Dale Hey Bungalow
 Preston Road
 Ribchester
 PR3 3XL *PROPOSED NEW ACCESS AND DRIVEWAY TO GARAGE*
 DDG REF 2317 CB/RF.

please ask for: Adam Birkett
direct line: 01200 414571
e-mail: Adam.birkett@ribblevalley.gov.uk
my ref: 3/2017/0813
your ref:
date: 11 October 2017

FORMATION OF A NEW ACCESS AND DRIVEWAY TO DALE HEY BUNGALOW, PRESTON ROAD, RIBCHESTER

Dale Hey Bungalow  
Preston Road  
Ribchester  
PR3 3XL **PROPOSED NEW ACCESS AND DRIVEWAY TO GARAGE**  
DBG REF 23/7 CB/AF.

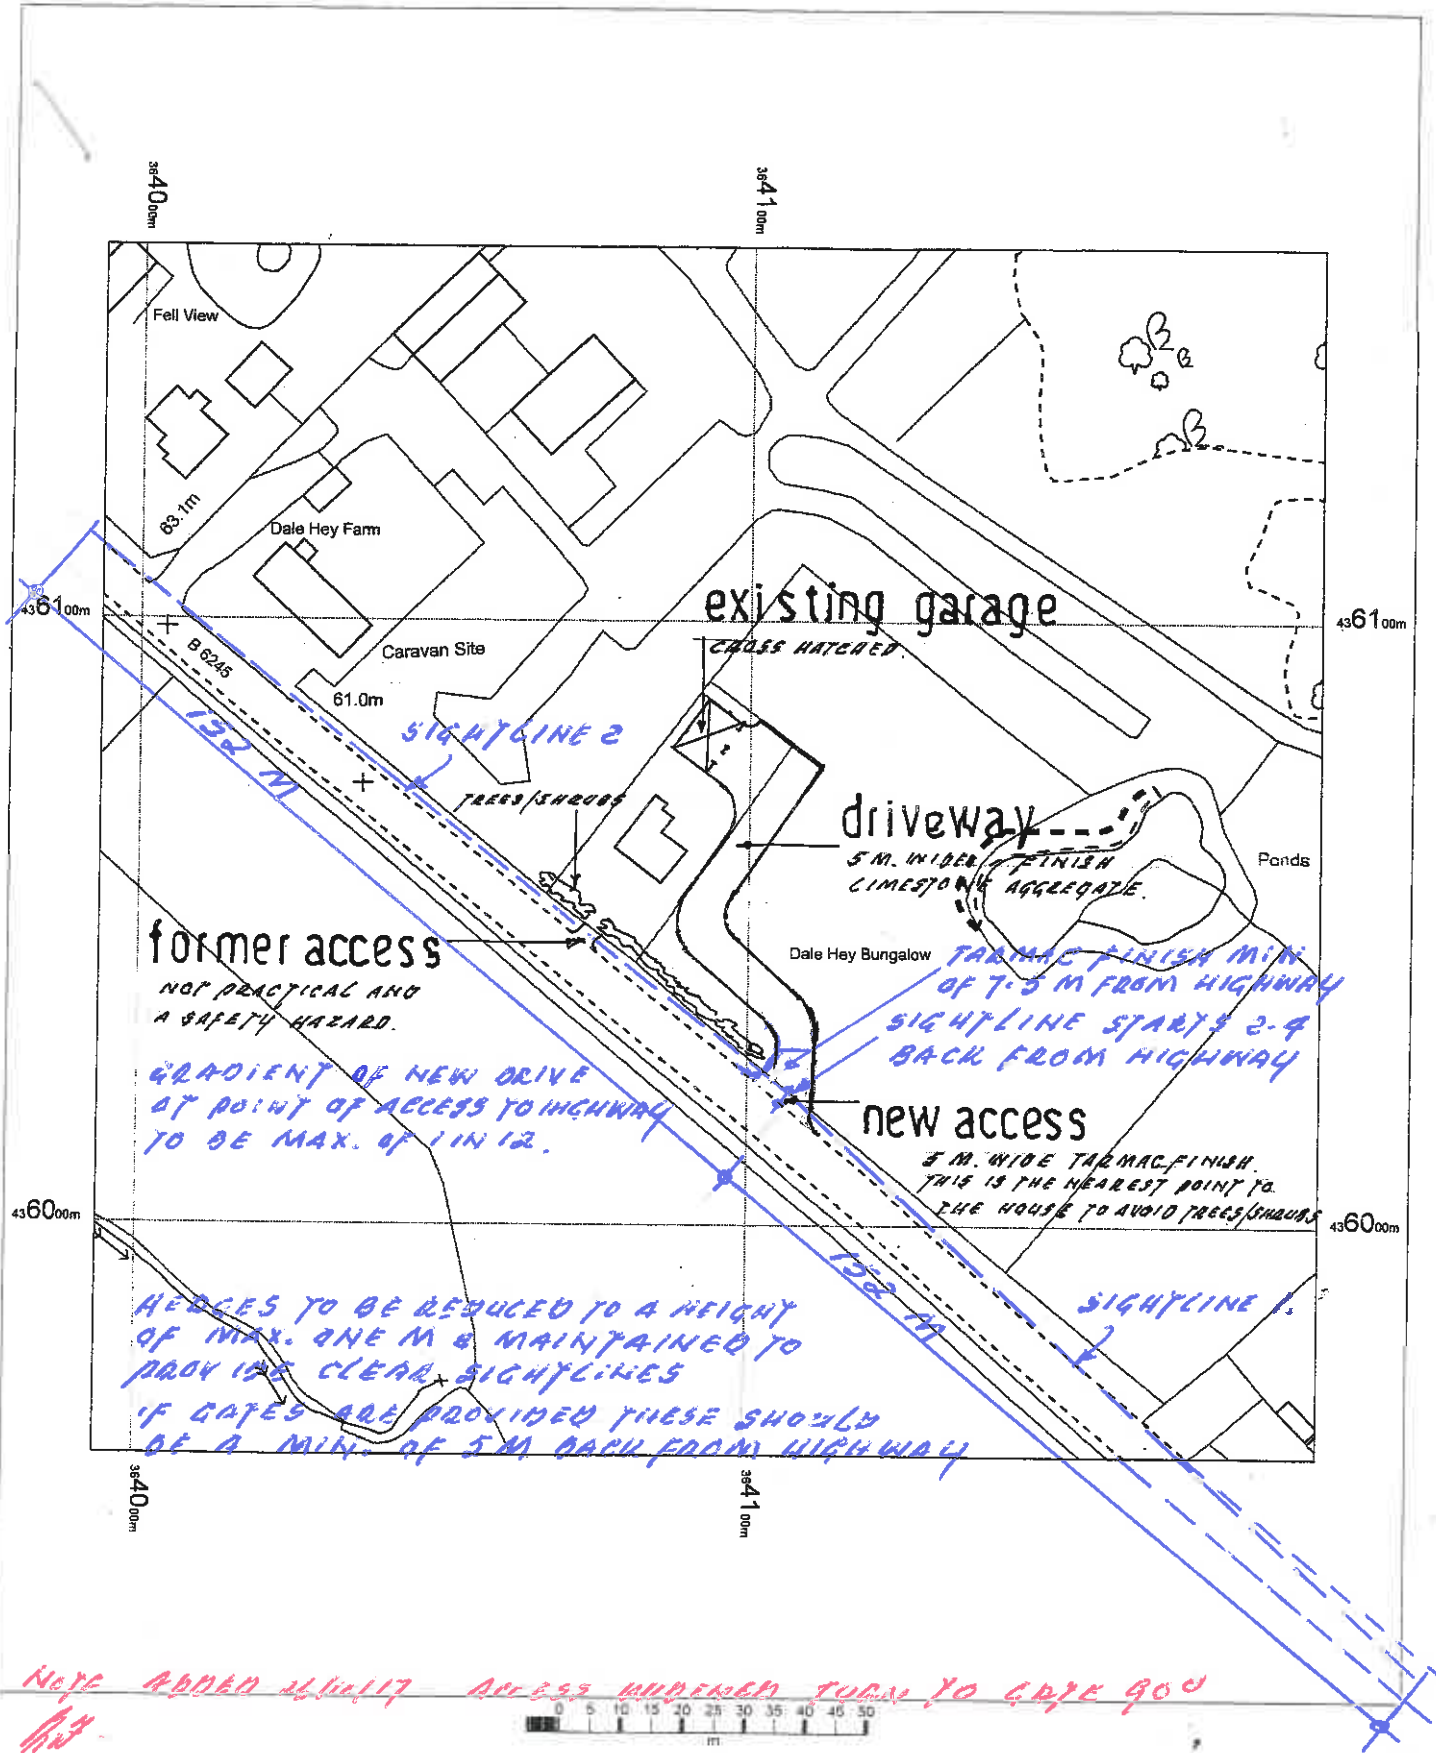
- Alterations be undertaken to achieve the necessary sightlines at the point of access. Sightlines both sides of the junction would need to be 200 metres if possible and at least 152 metres as an absolute minimum. These sightlines would need to be possible from a point that is 2.4m back from the edge of the highway. Such work may require some of the hedges to be reduced to and maintained at a height not exceeding 1 metre.

- A plan to indicate that there will be at least 7.5 metres of bound surface between the edge of the highway and the limestone aggregate road.
- Plans to indicate that any gates will be placed 5 metres back from the edge of the highway to ensure that they can pull clear of the highway. If vehicles of longer than 5 metres are expected to use this access point when it is completed then the gates should be set further back.

- Plans to indicate a cross section of the access point indicating the gradient of the new drive at the point of access to the highway.
